Application for a non-material amendment following a grant of planning permission.
Town and Country Planning Act 1990

ERECTION OF SINGLE STOREY SIDE EXTENSION AND REMOVAL OF EXISTING WALL TO FRONT OF PROPERTY

2019/1324

Location: 24 Bramble Way, Wymondham, NR18 0UN

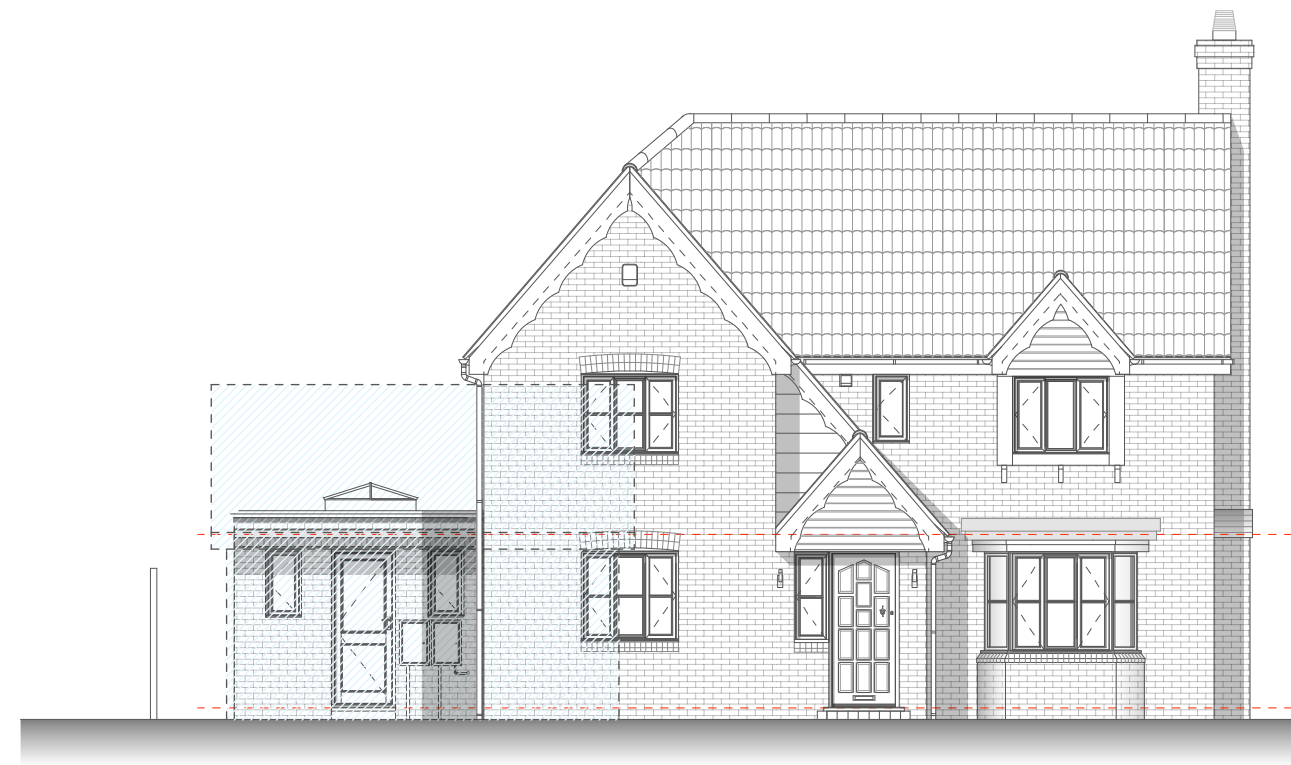
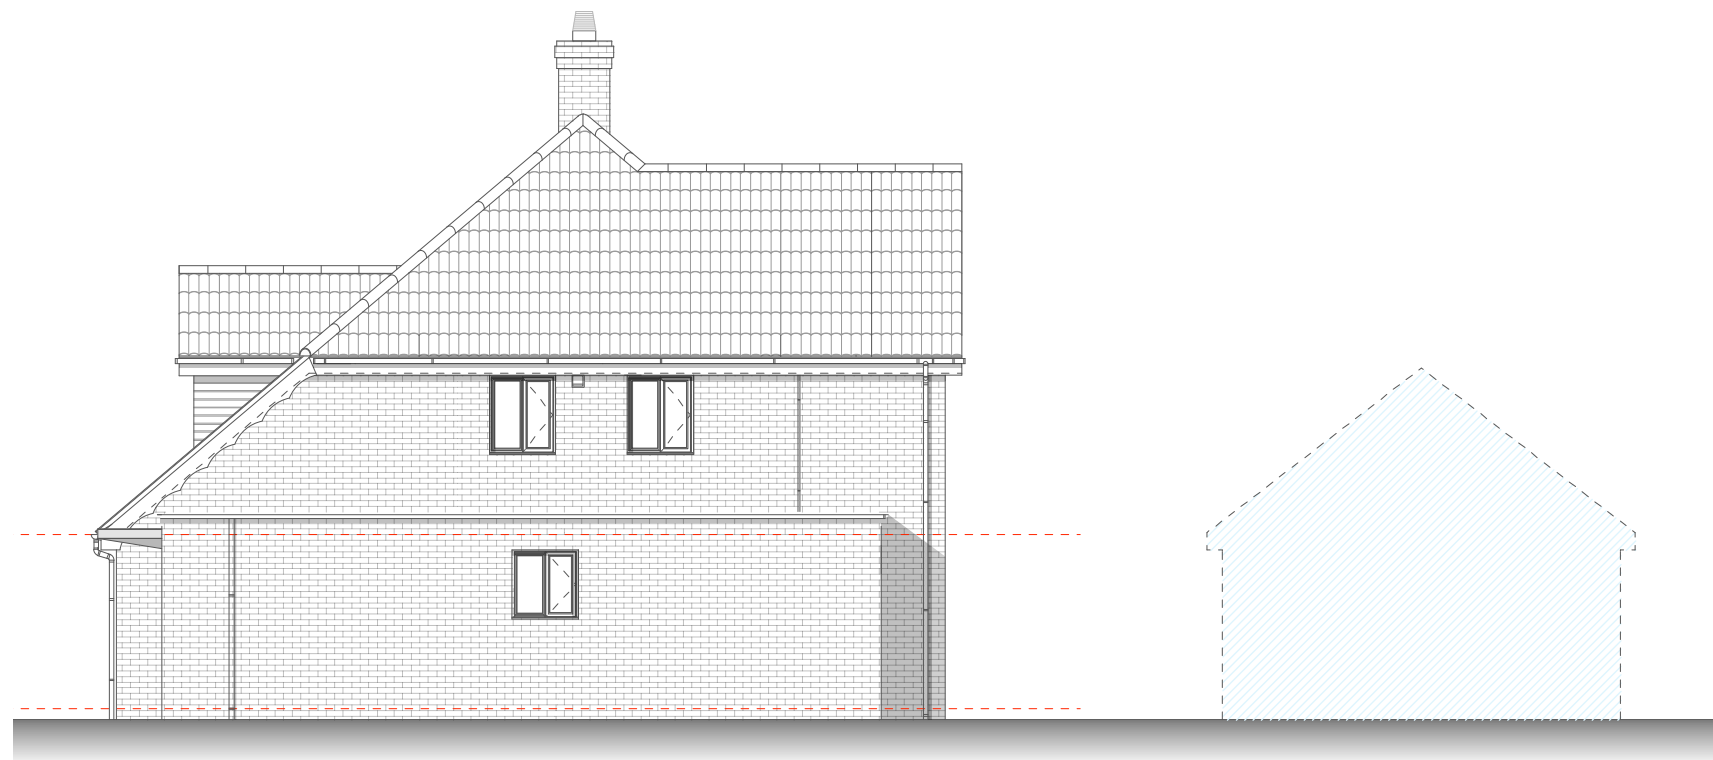
OMISSION OF PARAPET WALL ON APPROVE PLANS - REASONS:
① AVOID HAVING AN INTERNAL ROOF GUTTER / ② THE REAR PARAPET WALL WILL INTERSECT WITH THE EXISTING HOUSE ROOF LINE TOO HIGH. THEREFORE, TO KEEP WITH THE VISUAL APPEARANCE OF ALL THREE ELEVATIONS THE SAME, WE WOULD LIKE TO OMIT ALL 3 PARAPET WALLS, AND TO REVERT TO A TRADITIONAL FLAT ROOF WITH SOFFIT AND FASCIA DETAILS.
WE WERE ADVISED BY BUILDING CONTROL THAT FLAT ROOF SHOULD BE CONSTRUCTED AS A WARM ROOF INSTEAD OF A COLD ROOF AS ORIGINALLY PLANNED, WHICH MEANS WE WILL HAVE 125MM OF CELOTEX INSULATION ON TOP OF CEILING JOIST INSTEAD OF IN BETWEEN

- ① AVOID HAVING AN INTERNAL ROOF GUTTER
- ② THE REAR PARAPET WALL WILL INTERSECT WITH THE EXISTING ROOF LINE, TOO HIGH.
